# COLORADO

May 11, 2022

Re: Sand Creek Channel Designs CDs

**LOW FLOW CHANNEL 1
STA 9+00.00 TO 19+00.00**

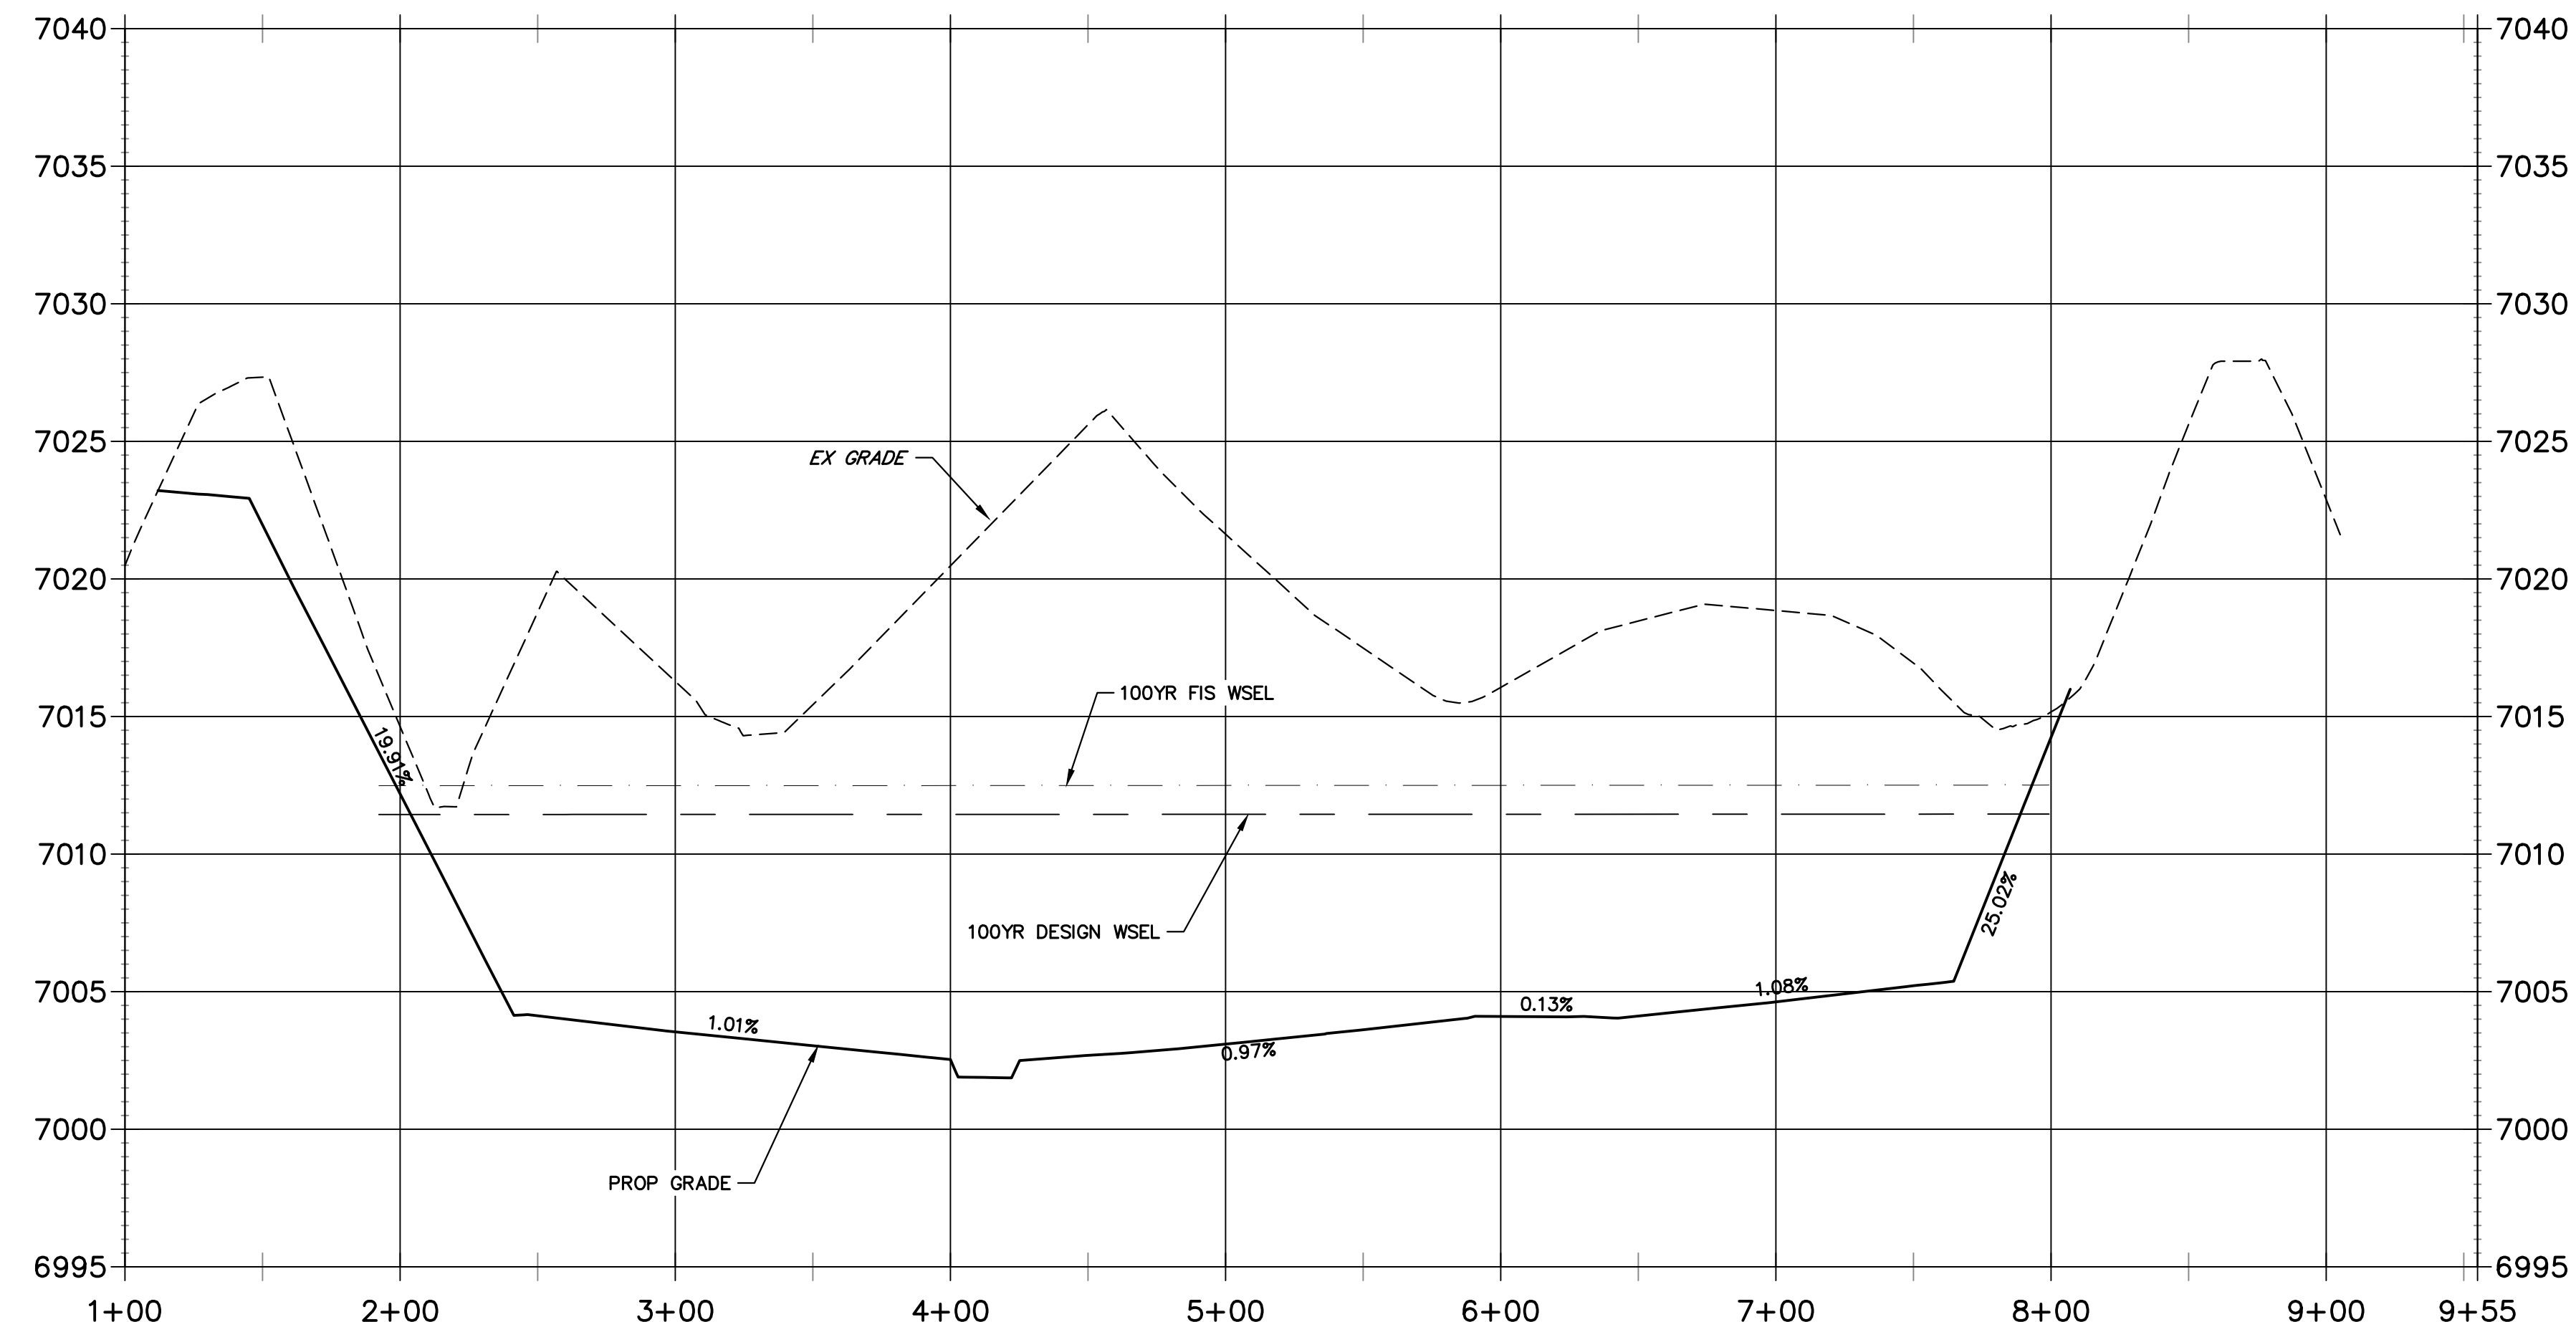
The design does appear to have a low flow channel, but CPW feels that it is very important to reiterate that a low flow channel remain incorporated into the stream and drop structure design. Many native fishes and amphibians have difficulty navigating high velocity and sheet flows that many drop structures create. The design of the low flow channel should allow for upstream and downstream migration of fishes and amphibians that is essential for their reproduction, dispersion, distribution, and abundance. If designed properly, this channel should not compromise the integrity of the grade control structure and will be beneficial to wildlife inhabiting the stream.

GRouted STEPPED BOULDER DROP #1 DETAIL
PLAN VIEW
 SCALE: 1"=20"

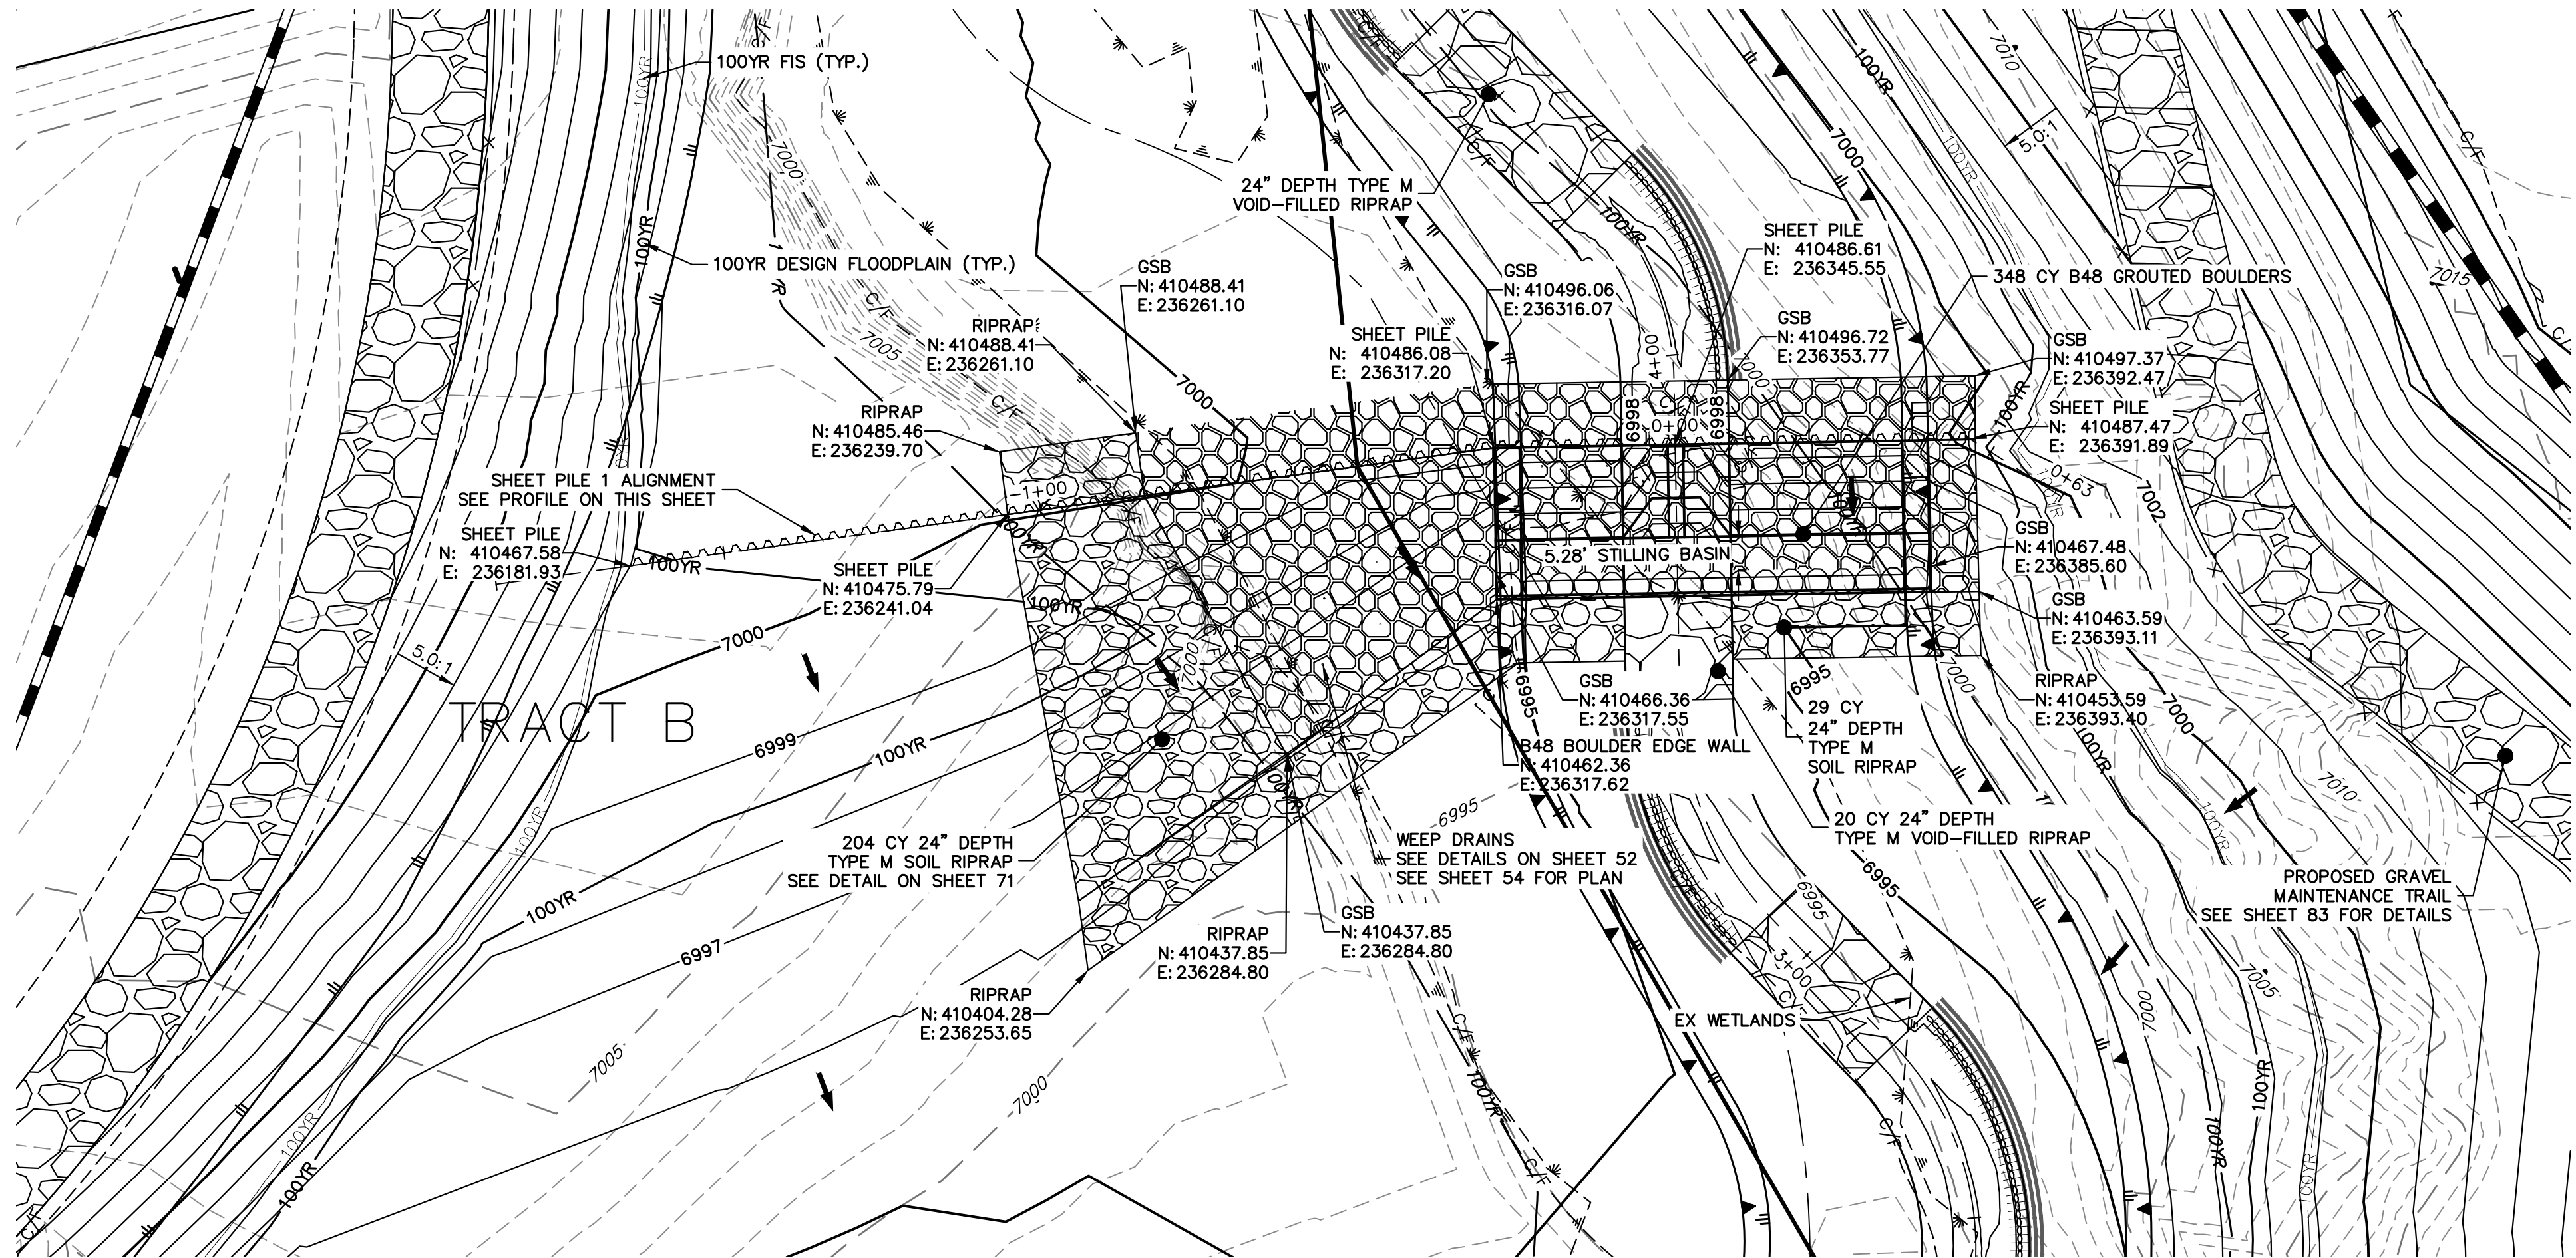
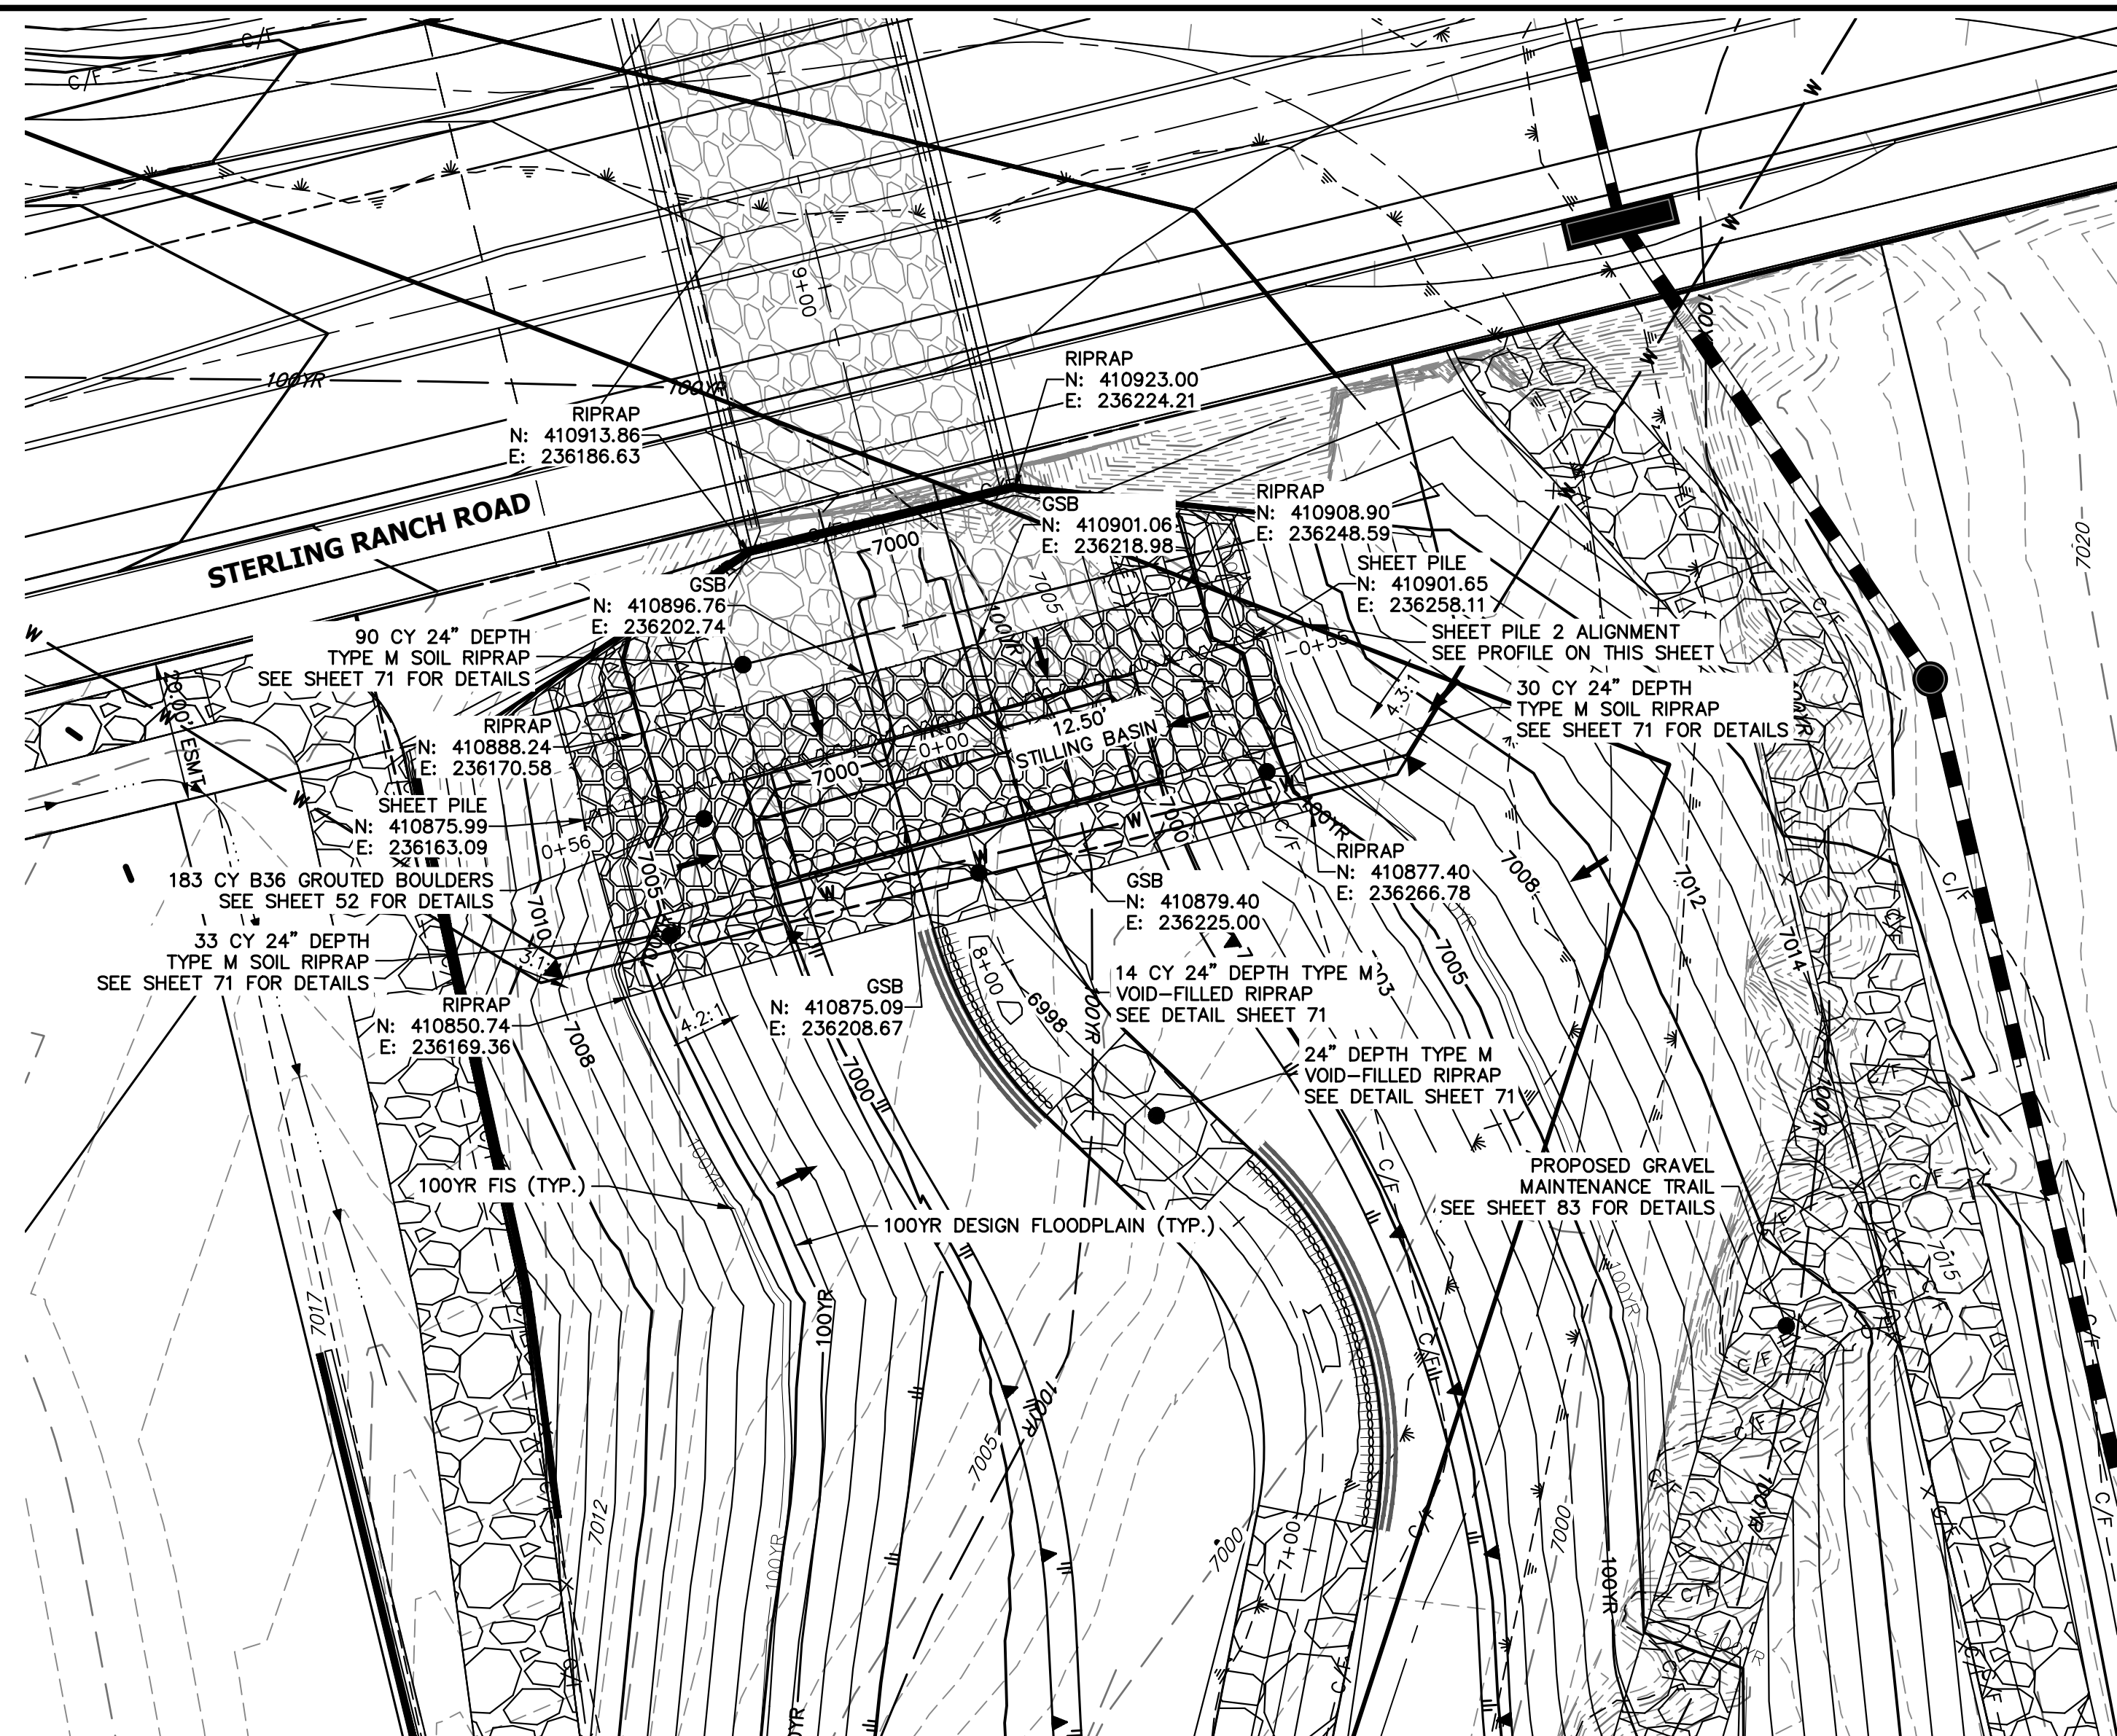
CPW noted in the designs of the channel that most of the rip-rap throughout the project are not grouted. However, there were sections of the channel design that were grouted drop structures. CPW recommends using non-grouted rip-rap throughout all portions of the plan.

Vegetation and tree roots are more stable in non-grouted rip-rap and it can help provide habitat for small mammals. This not only benefits wildlife, but makes the construction more aesthetically pleasing.
